# A47/A11 Thickthorn Junction

## **9.7 Draft Development Consent Order - Schedule of Drafting Changes for Deadline 6**

**DRAFT DEVELOPMENT CONSENT ORDER:  
SCHEDULE OF DRAFTING CHANGES FOR DEADLINE 6**

DRAWING TITLE
**RIGHTS OF WAY AND ACCESS PLANS
 REGULATION 5(2)(k) AND 5(2)(o)
 SHEET 5 OF 7**

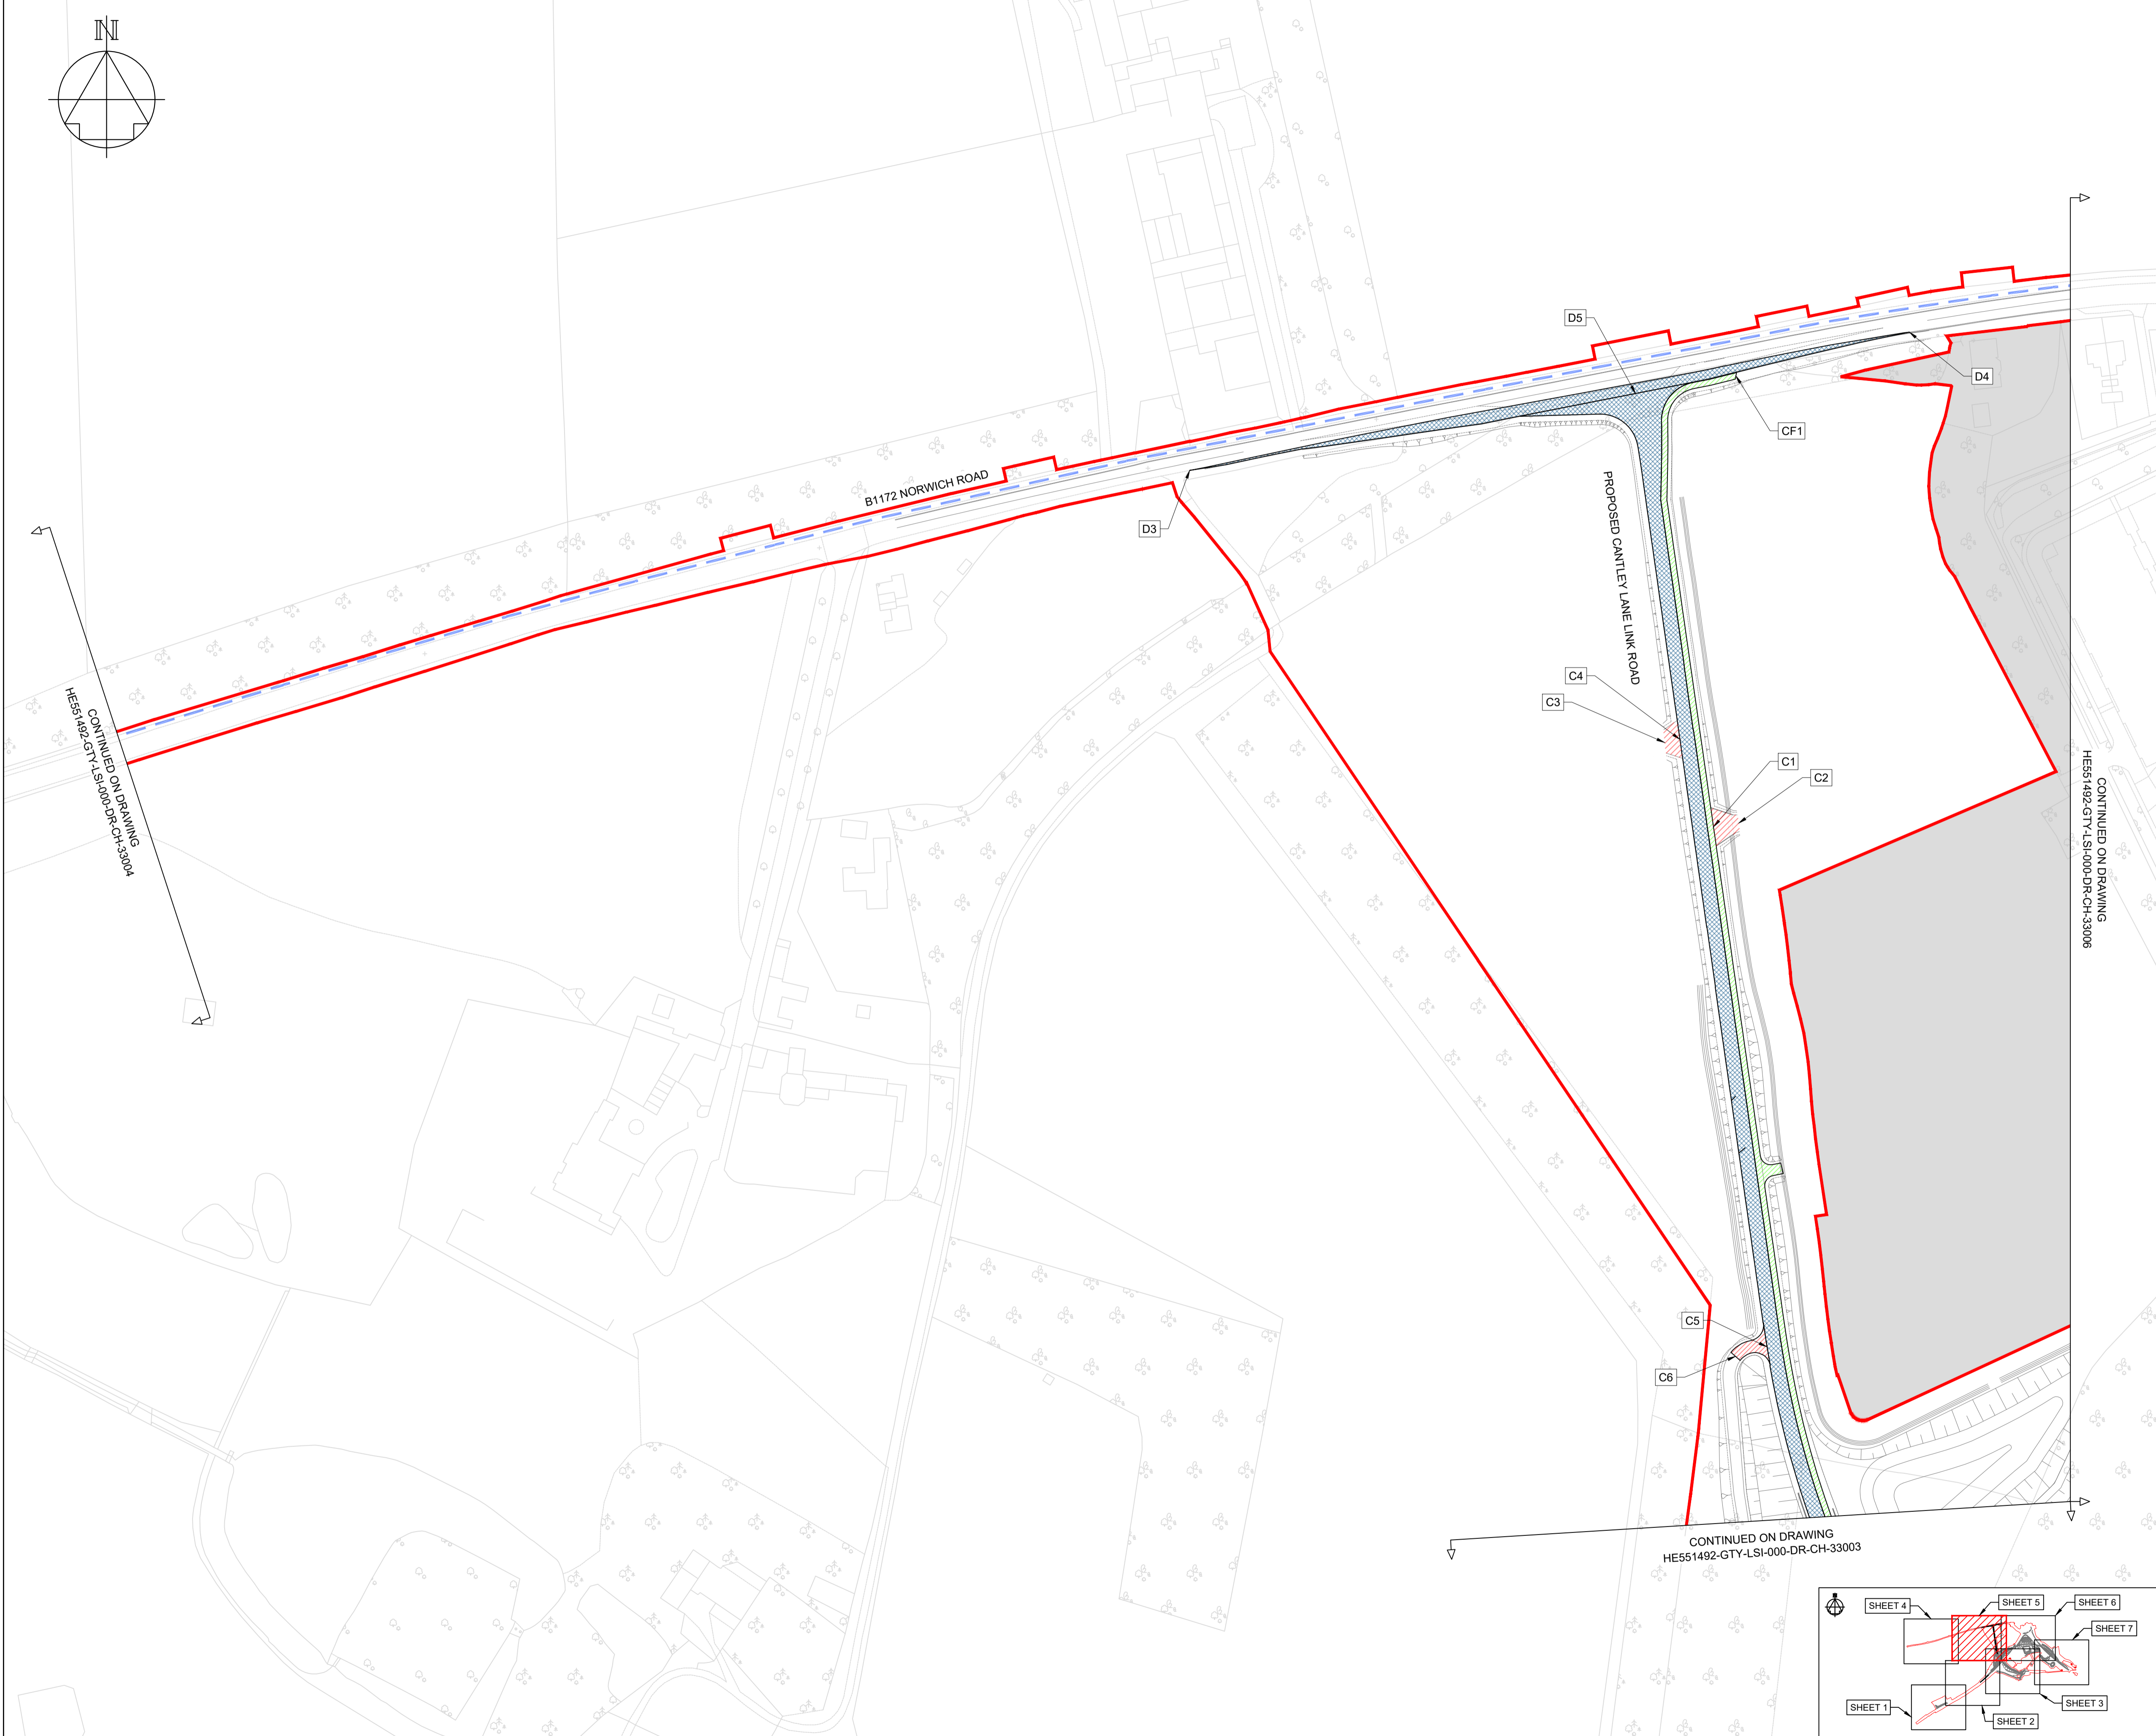
Schedule 4, Permanent Stopping Up of Highways and Private Means of Access & Provisions of New Highways and Private Means of Access, The rights of way and access plans – sheet 5, Reference C3 to C4	The descriptions of the accesses have been updated. The distance of the private access to an agricultural field from point C3 to point C4 on the proposed Cantley Lane Link Road has been reduced from 8 metres to 6 metres	This change was made in association with the non-material change request submitted at Deadline 4 ( <b>AS-017</b> ). The new access being created on the west side of the proposed Cantley Lane Link Road. C3 to C4 has been moved 85 metres south.	N/A	N/A
Schedule 7, Land Over Which Temporary Possession May Be Taken, Plot 7/12a	The entry relating to 7/12a has been removed from the dDCO.	This change was made in association with the non-material change request submitted at Deadline 4 ( <b>AS-017</b> ). Further assessments deemed that there was no need to carry out any works to the property on Intwood Road or acquire	N/A	N/A
